REQUEST FOR ADDITIONAL INFORMATION - SSD 10437

This letter provides a response to the Request for Information (RFI) prepared by the Department of Planning, Industry and Environment (DPIE) dated 17 February 2021. This letter provides supplementary information for the assessment of SSD 10437 relating to the Waterloo Metro Quarter, Southern Precinct Over Station Development (OSD).

Level 09

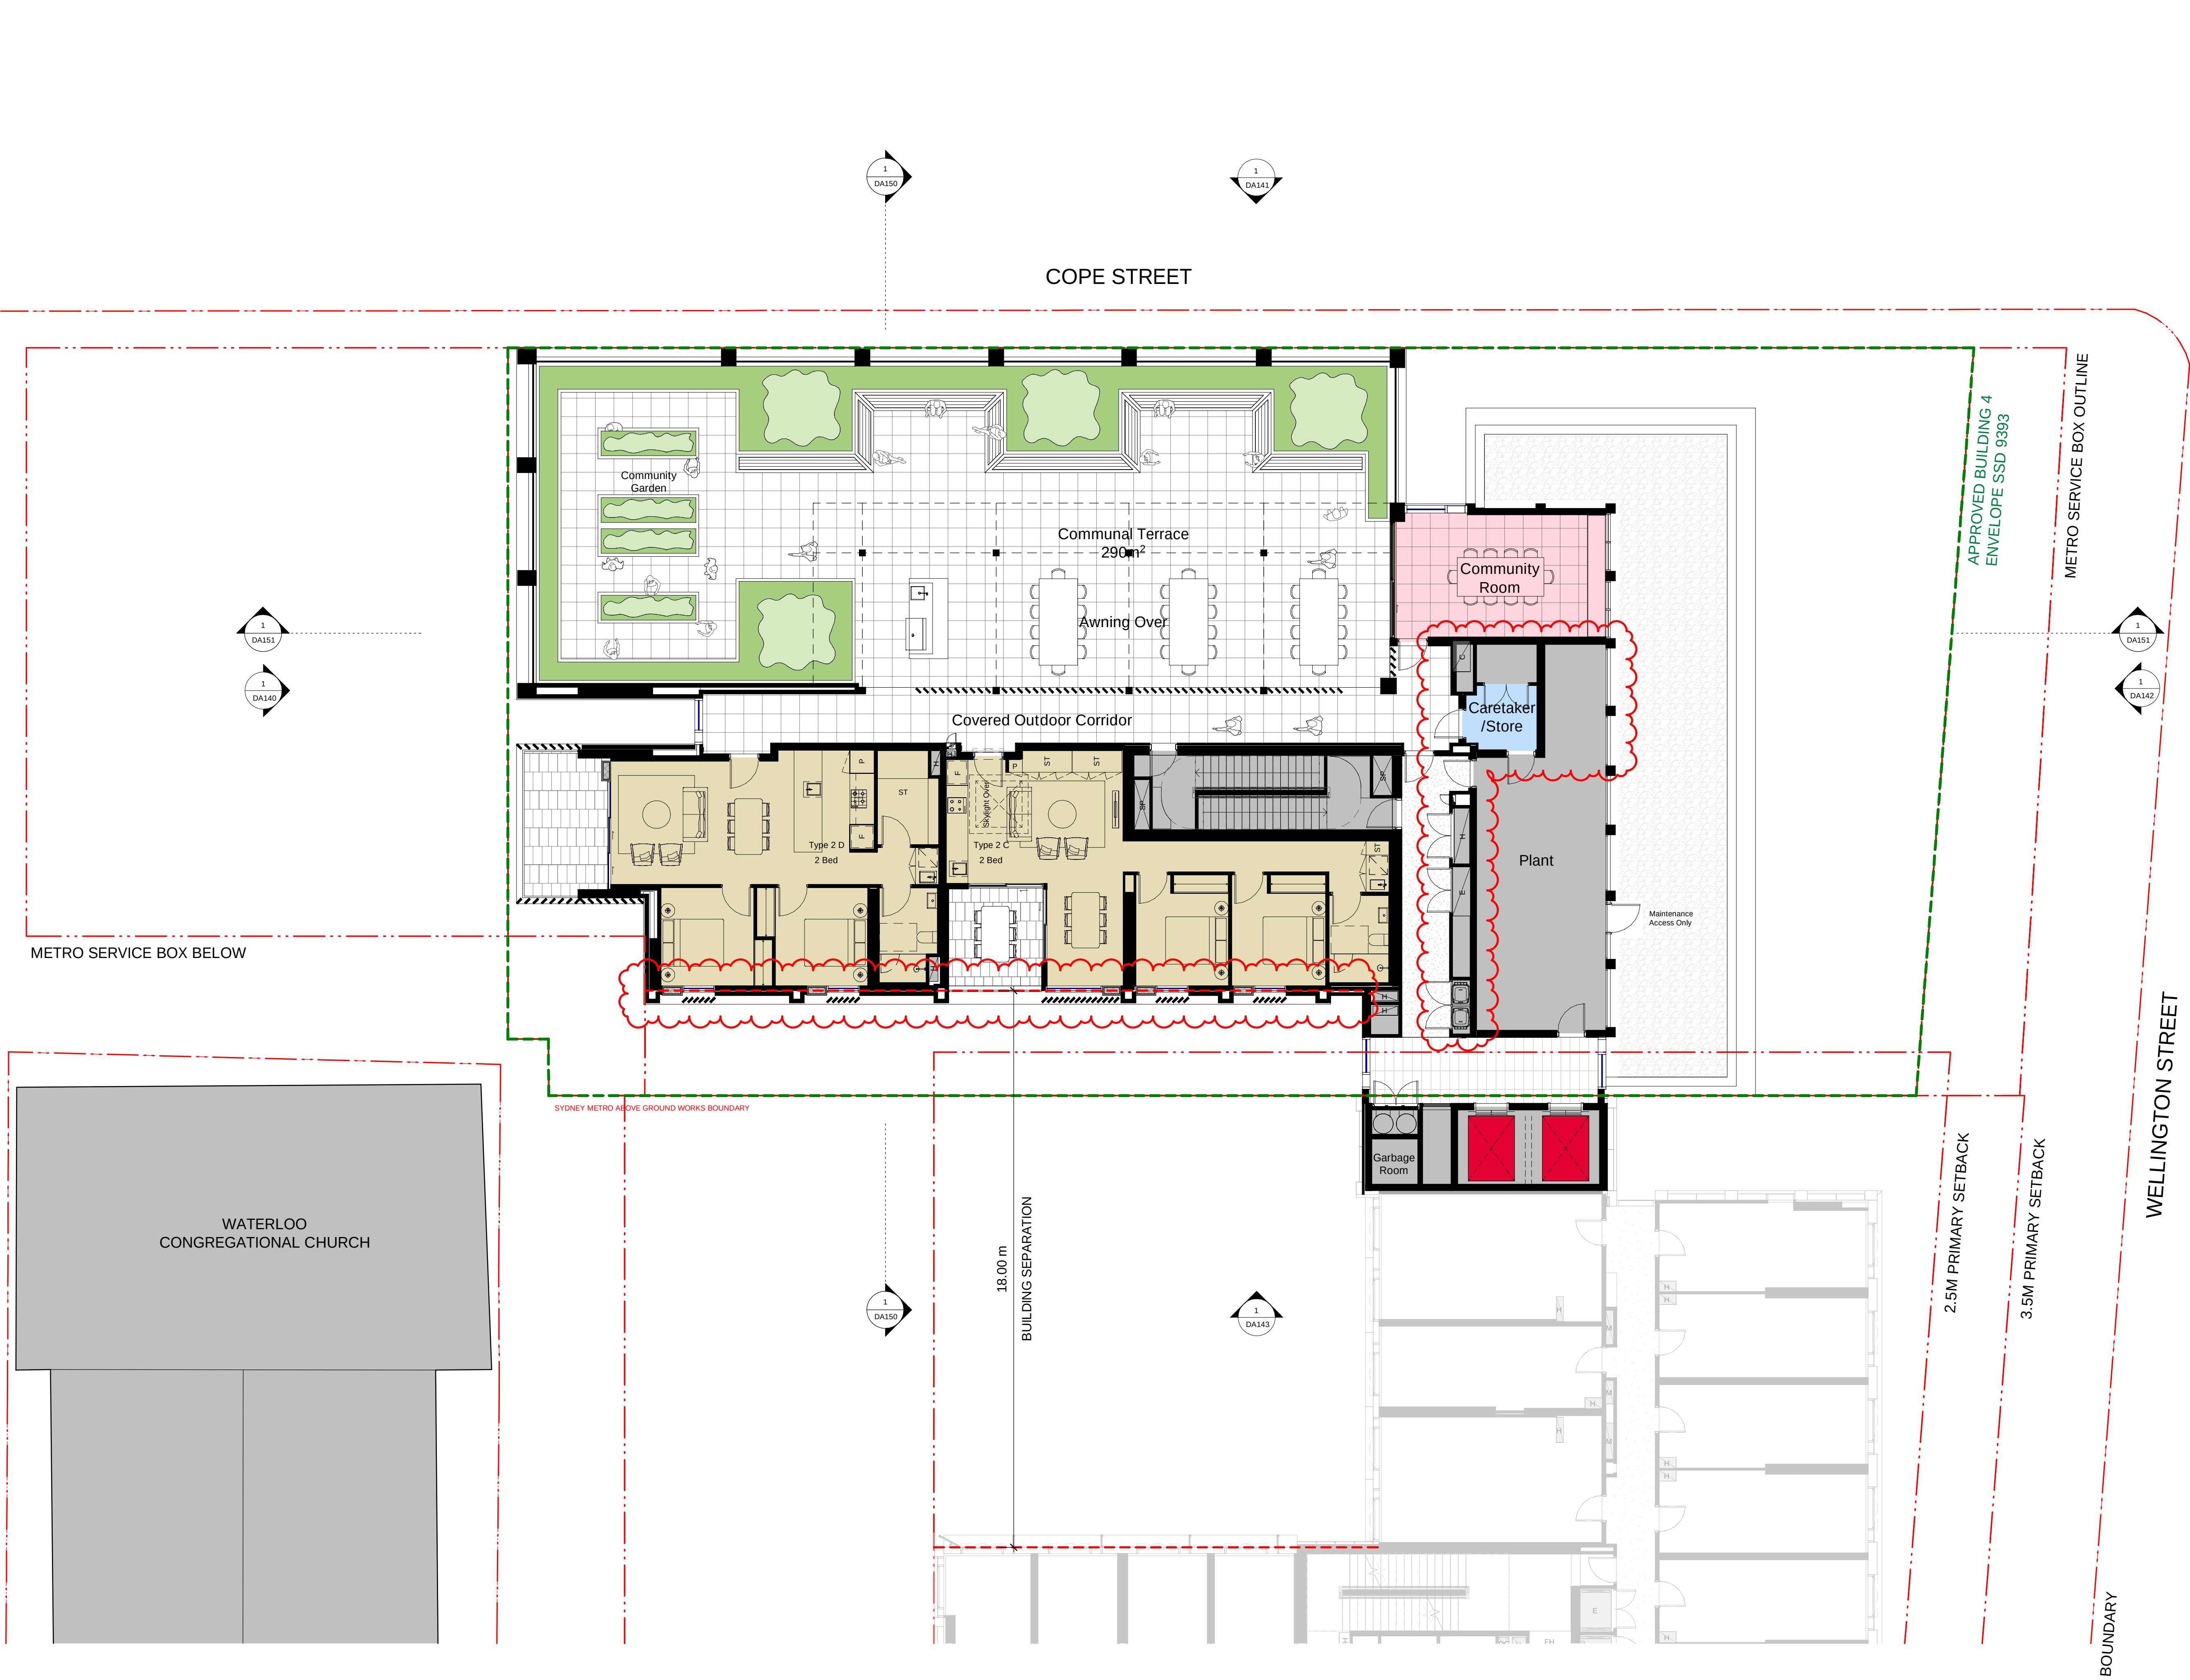
- Built Form
 - Item 11.06 – The Panel notes that the proposed thermal comfort strategies for apartments facing east and west exceed minimum Section J requirements for thermal comfort.
 - Item 11.07 – The Panel commends the additional depth to sunshades to reduce solar thermal impact to levels 16 – 23.
 - Item 11.09 – The Panel accepts the design amendments proposed to screens to improve privacy and shading to Building 3 east facade and Building 4 west facade.
 - Item 11.10 – The Panel accepts the proposed alternative cross ventilation solution for apartments where this cannot be achieved via operable windows.
 - **The Panel recommends improving the performance and visual amenity of the building 4 roof by adding a setback parapet to allow the addition of gravel and/or low planting.**

- Reconfiguration of services
- Addition of screened louvres to western façade of the Social Building in response to the DRP comments.
- Reconfiguration of caretaker/store room

Roof Plan

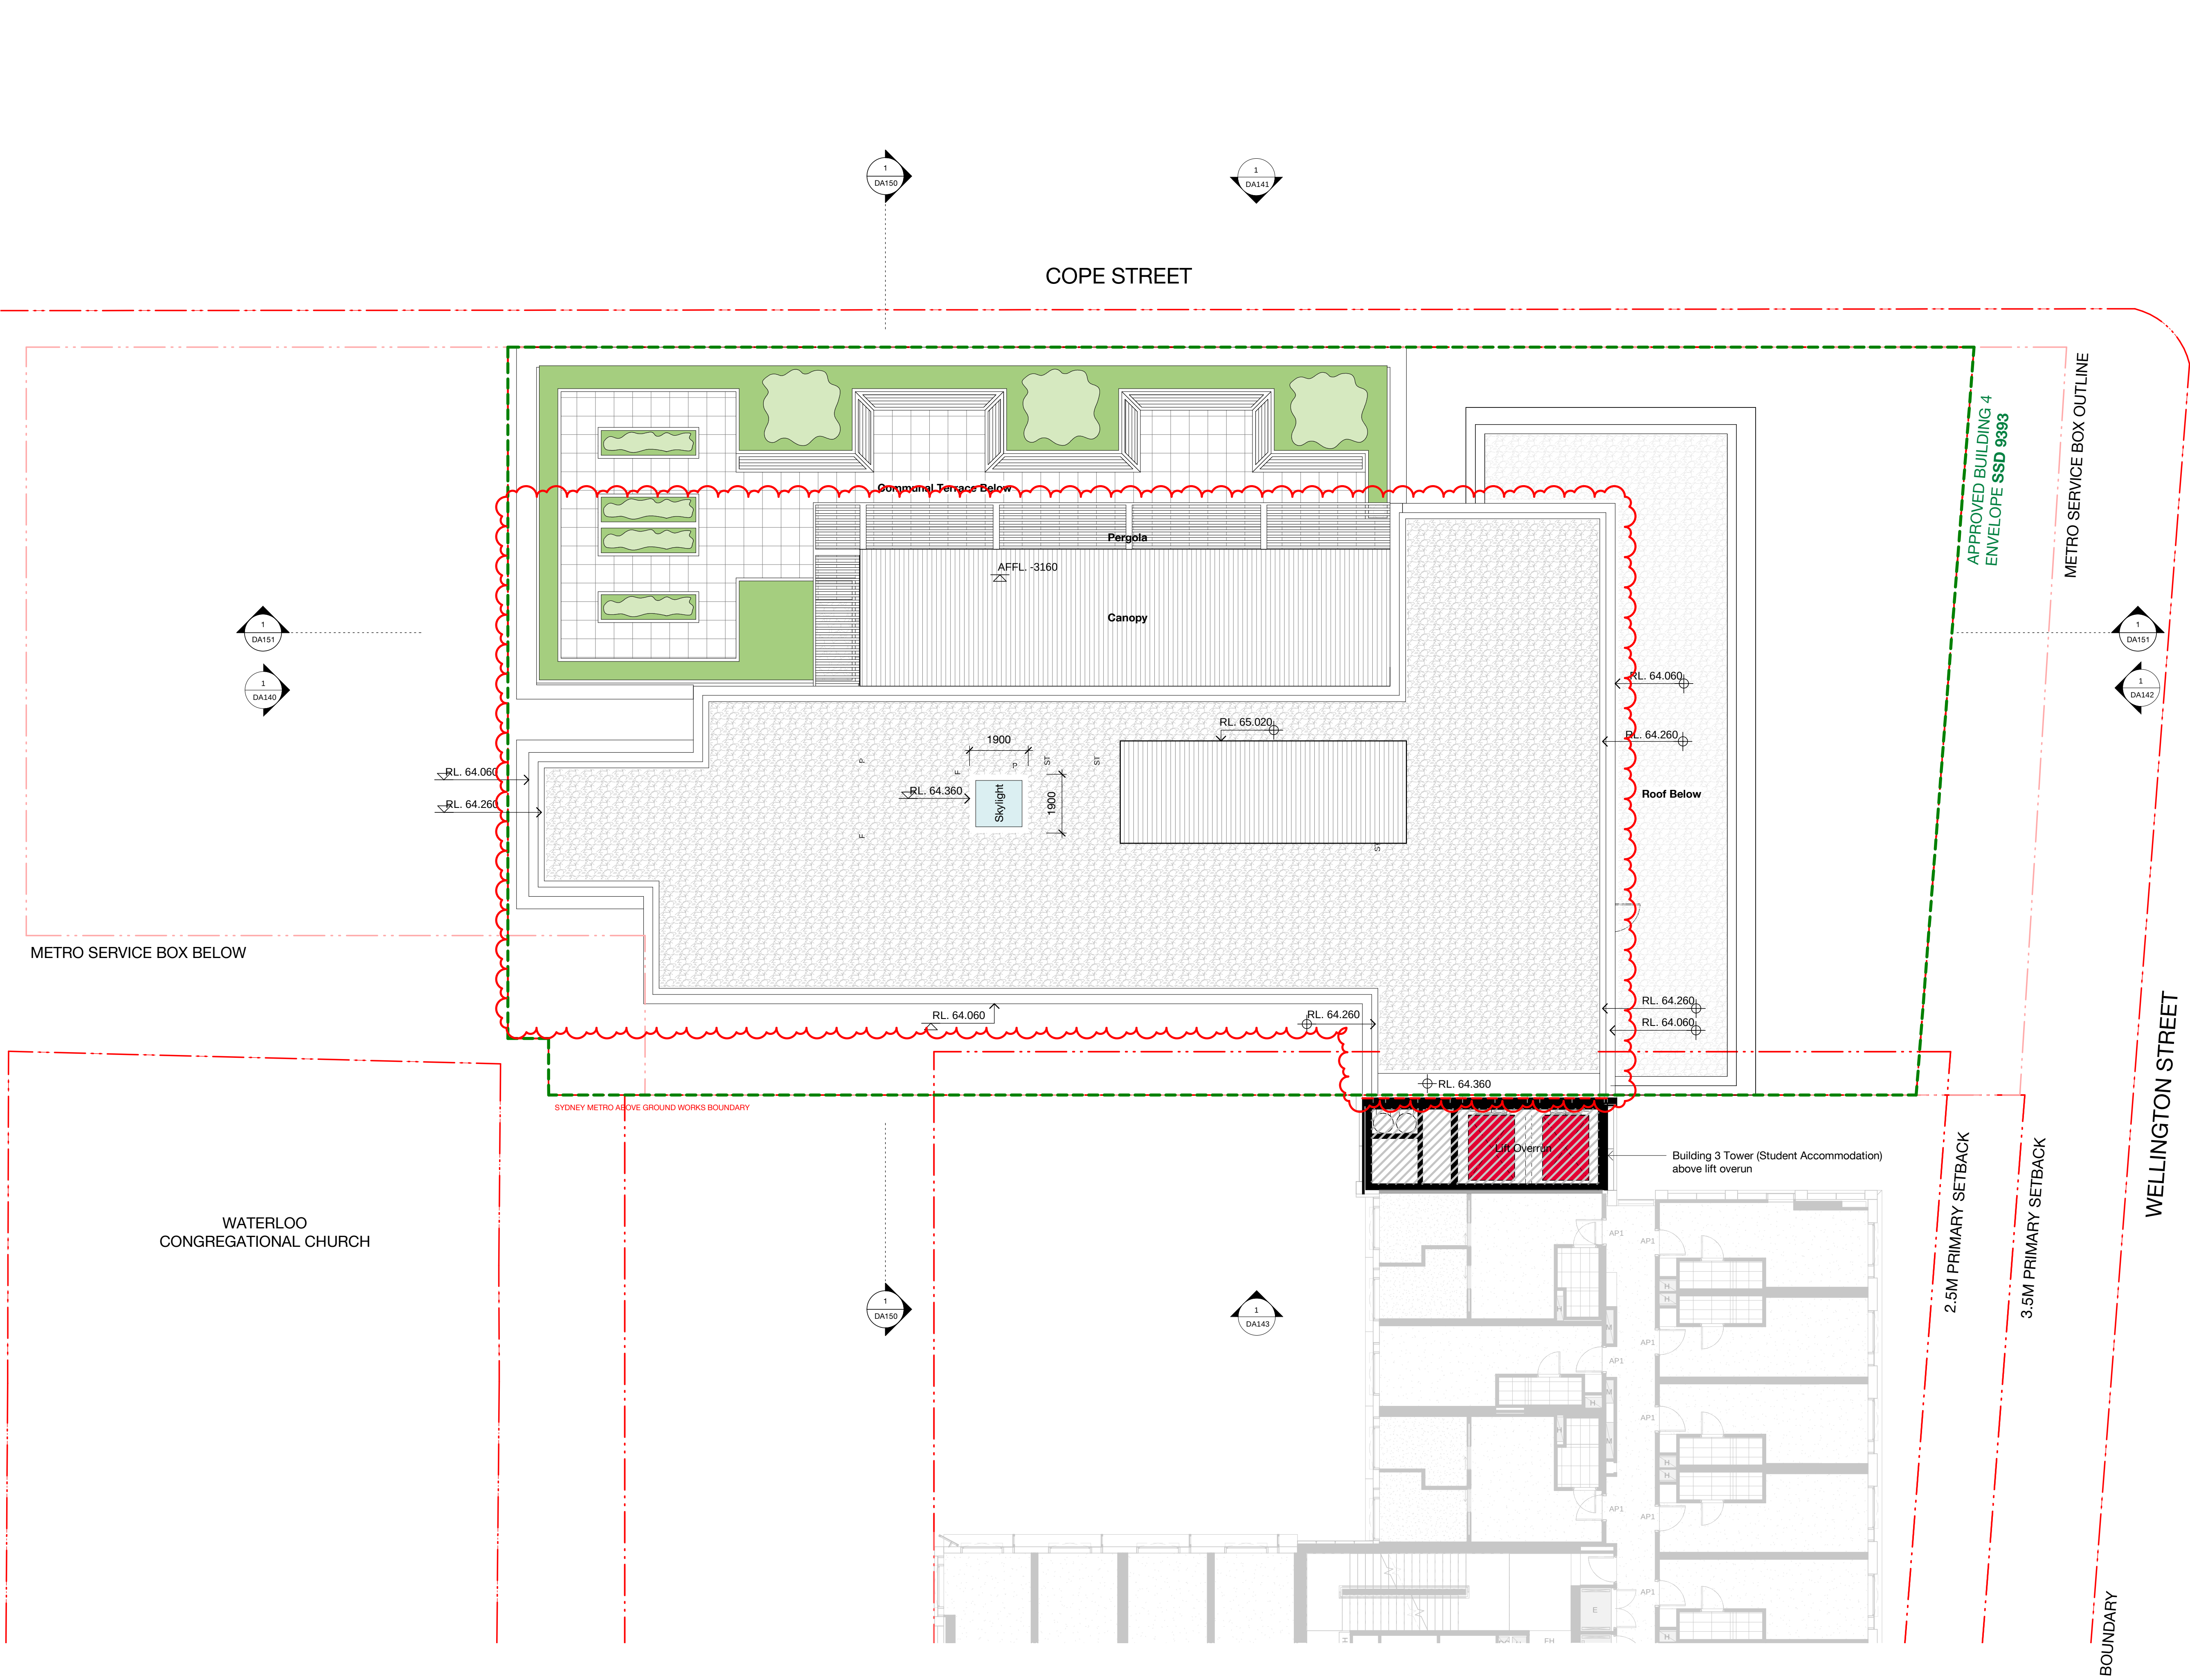
DRP Comment: *The Panel recommends improving the performance and visual amenity of the building 4 roof by adding a setback parapet to allow the addition of gravel and/or low planting*

Design Response: The roof parapet of Building 4 has been set back from the roof edge. As illustrated in Figure 1, a gravel finish is proposed to improve the visual amenity of the roof. To further reduce visual impacts, a louvred enclosure over the fire stair is proposed to house the stair pressurisation plant equipment. All other plant equipment is housed in the Level 9 plant room. This plant space has been partially 'sunken' below the roof slab to minimise visual impact.

- Setback of roof parapet
- Increase the roof parapet to RL 64.26 (a minor 100mm increase from the proposed) as the result of structural connection refinement between Building 3 and 4.
- Increase in size of terrace pergola to provide improved wind and weather protection
- Addition of a roof plant enclosure
